| Application Ref: | 3/2024/1045 | | |  <div>Ribble Valley Borough Council</div> <hr/> www.ribblevalley.gov.uk |
| DELEGATED ITEM FILE REPORT: | | | | REFUSAL |

| Development Description: | Regularisation of extension and conversion of barn to dwelling. |
| Site Address/Location: | Betty Barn, Slaidburn Road, Waddington, BB7 3JQ. |

As built Elevations

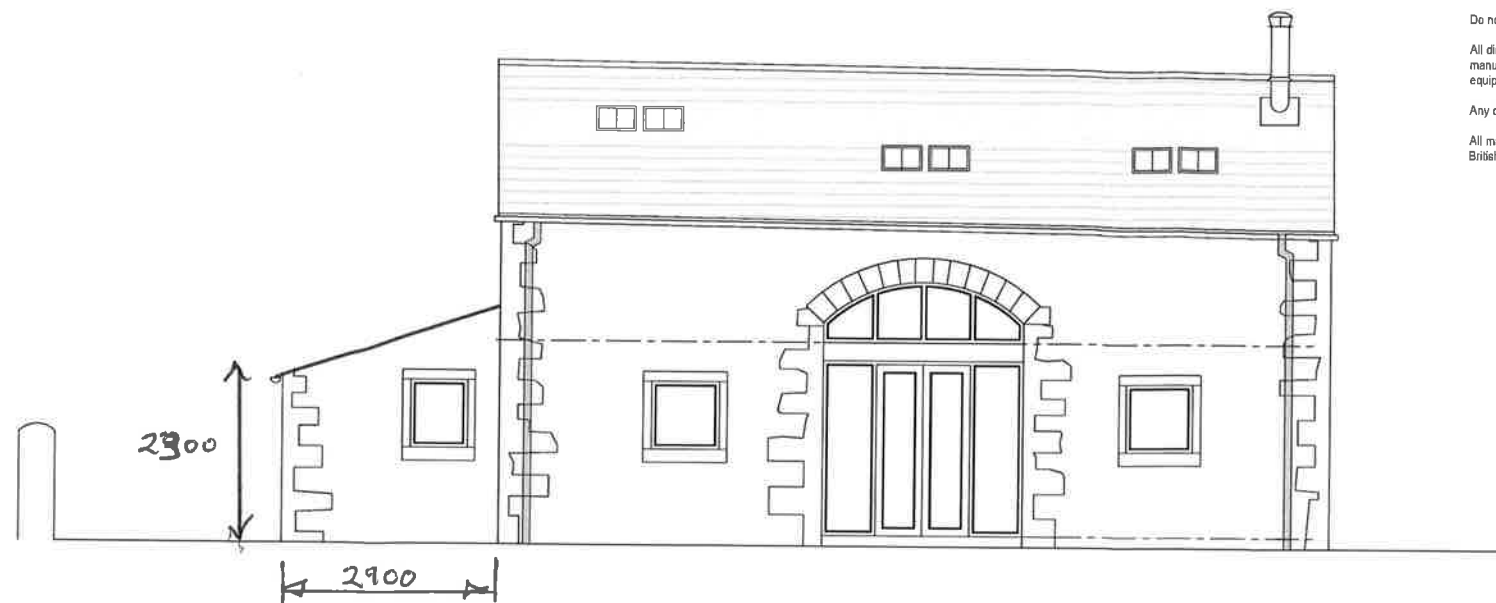
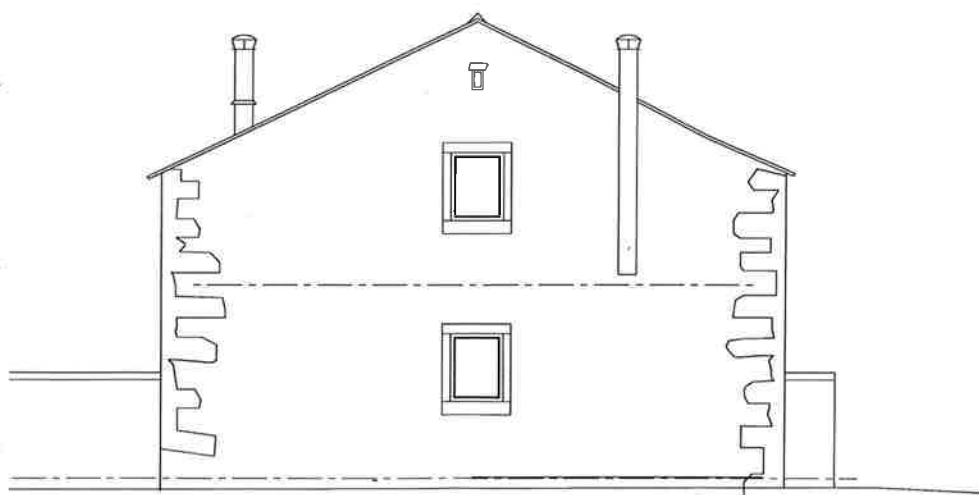
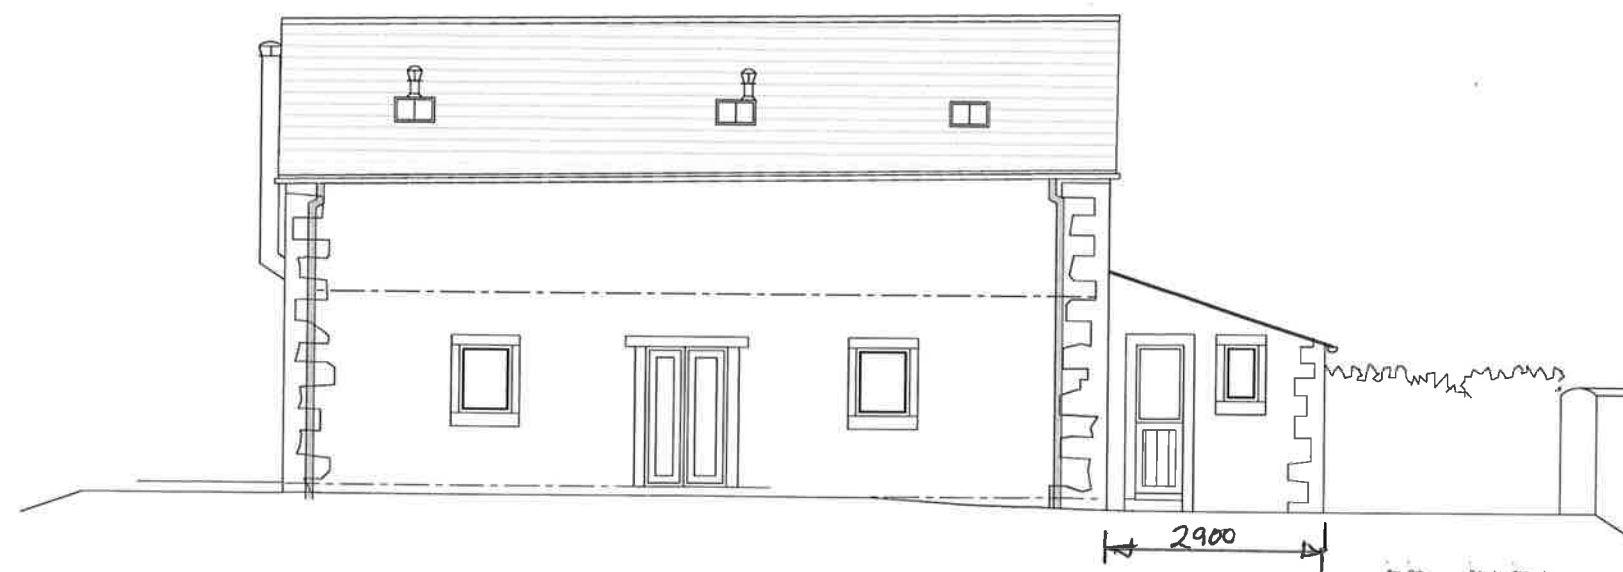
In contrast, the unauthorised scheme of residential conversion comprises noticeable deviations from the approaches outlined above with regards to its implemented sequence of openings. These deviations include the infilling of two historic openings on the barn's Western gable and the introduction of new ground and first floor window openings which read as overtly domestic introductions by virtue of their regimented and symmetrical alignment. An elongated flue pipe has also been introduced to the same elevation which is equally at odds with the historic character of the building, with this feature protruding above the barn's Southern roof slope.

In a similar vein, a former doorway opening has been infilled on the barn's Northern elevation with a new ground floor window opening introduced and existing ground floor window opening enlarged which has resulted in a regimented and symmetrical sequence of openings between the two windows and cart entry feature which reads as overtly domestic. In addition, the building's smaller flue pipe has been installed in a higher position within the building's Northern roof slope relative to its approved position from application 3/2022/0965 to the extent that the smaller flue pipe now protrudes above the barn's Northern roof slope.

Similarly, a new ground floor window opening has been introduced to the barn's Southern elevation with an adjacent existing ground floor window opening having also been enlarged, both of which has resulted in a regimented and symmetrical sequence of openings between the two windows and centralised vertical opening which reads as overtly domestic. Furthermore, three roof lights have been installed to the barn's Southern roof slope in an overtly regimented fashion which do not appear to reflect the alignment or proportions of the roof light openings shown on the application's as-built elevation drawings.

Accordingly, the implemented scheme of fenestration has little to no reference to the randomised sequence of openings typically seen within agricultural buildings, with the unauthorised works having resulted in the loss of historic building fabric and the obscurement of several of the barn's historic openings which in turn has detracted from the barn's historic character. Furthermore, the Southern and Northern profiles of the barn building (and Western facing flue feature) are publicly visible on approach to the site from Slaidburn Road therefore the unauthorised development carries a discernible visual impact.

As such, the unauthorised scheme of residential conversion, by virtue of its fenestration and domestic features, is considered to constitute an incongruous and unsympathetic form of development which if retained would have a harmful urbanising impact that would neither enhance or conserve the visual amenities of the surrounding National Landscape. Retention of the unauthorised development would

| 01: | The proposed development, by virtue of its fenestration and domestic features, is considered to constitute an incongruous and unsympathetic form of development which if retained would have a harmful urbanising impact that would neither enhance or conserve the visual amenities of the surrounding National Landscape. The proposed development would therefore fail to satisfy the requirements of Paragraph 135 (c) and 189 of the NPPF and Key Statement EN2 and Policies DMG1 and DMH4 of the Ribble Valley Core Strategy. |

Betty Barn Sladburn Road Waddington	Shed	AV Town Planning Chartered Town Planning Phone: 01282 891744 Email: enquiries@avtownplanning.co.uk 11-13 Kempster Road, Waddington, Lincolnshire, BB9 5SZ	Drawing No: ATKIN06 - Dwg 04 Client: S Atkinson Date: 14/07/25 Scale: 1:50 @ A4
---	------	--	--

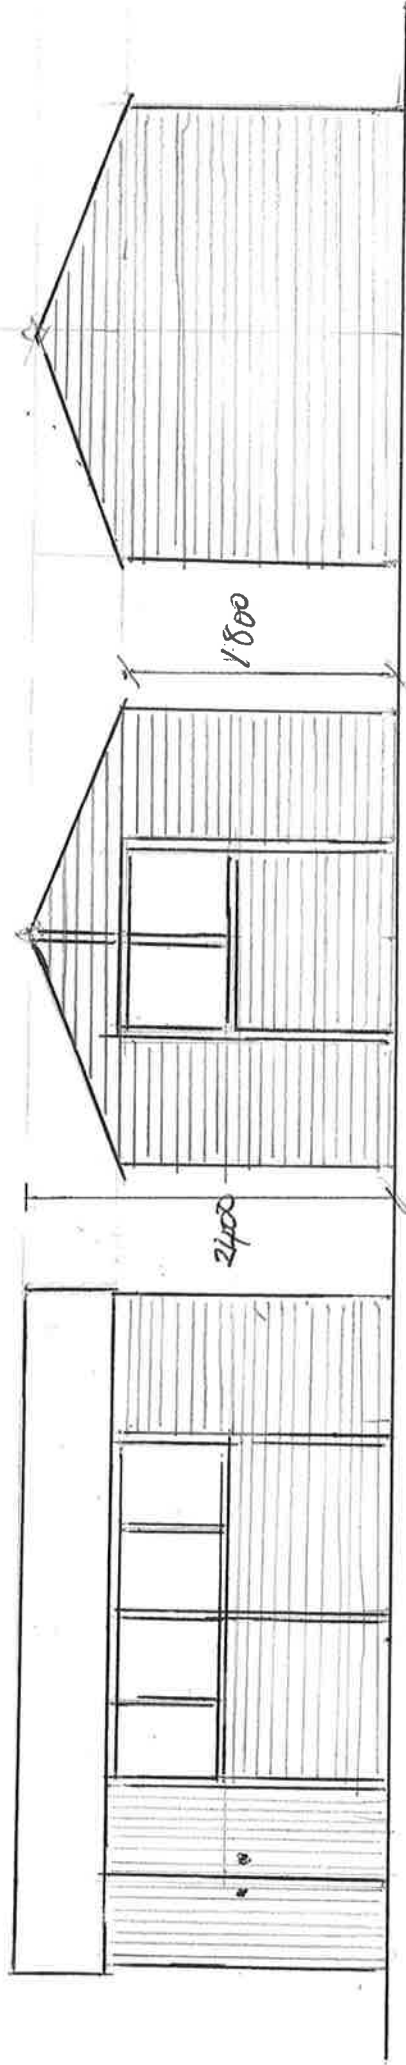
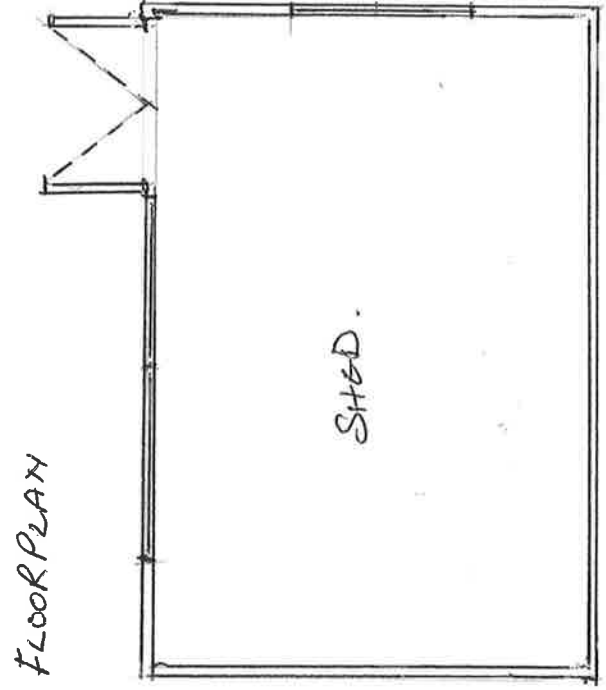
The secure cycle storage shed proposed for the site would mirror the design and external appearance of the cycle shed approved under previous application 3/2022/0965, albeit with the cycle storage shed sited slightly further North-west of its approved position but still in close proximity to the barn's Western gable end. In a similar vein, the proposed storage shed would be a modestly sized structure with respect to its height and footprint and this would be sited in reasonably close proximity to the Eastern profile of the barn, with its timber detailing being in keeping with the rural vernacular of the area. As such, these aspects of the proposal are considered to be acceptable with respect to their siting, design and external appearance.
